Development Control
Ribble Valley Borough Council

Your ref: 23.0424
Our ref: D3.23.0424
Date: 12th September 2023

Address: Sunnyside Barker Lane Mellor

Proposal: Proposed removal of existing detached single storey bungalow and reinstatement of larger 3 bedroom bungalow

PROPOSED SITE PLAN. SCALE 1:200

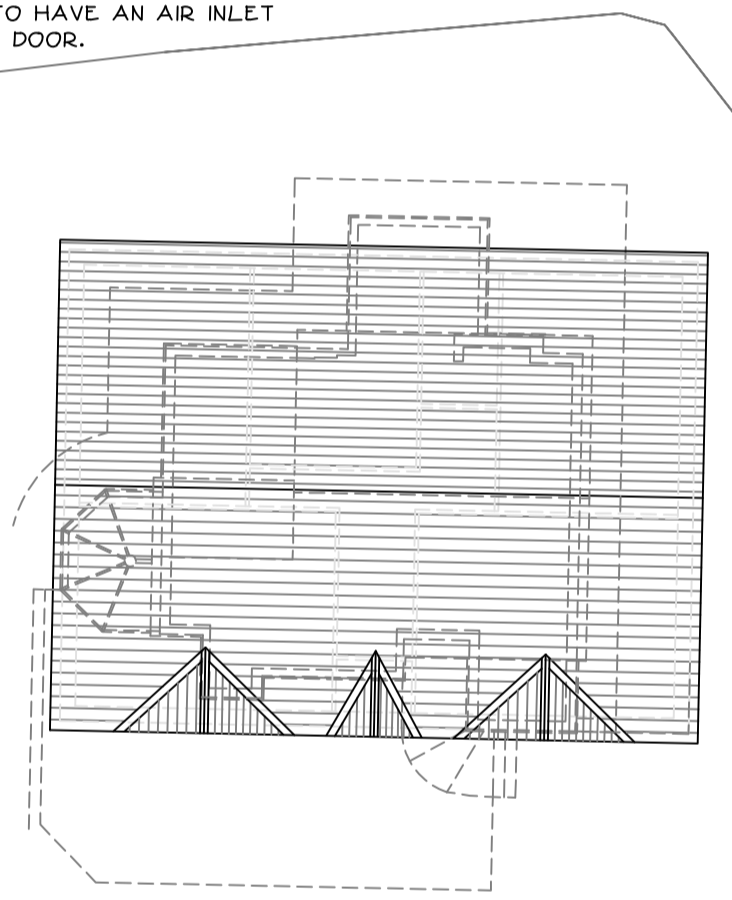
There are no plans submitted to show the car parking associated with the dwelling. A plan is requested to show 2 car parking spaces together with a secure, covered cycle store for 2 bicycles. The dwelling should provide an electric vehicle charging point.

Lancashire County Council acting as the Highway Authority requests further information regarding the car parking provision for the dwelling.
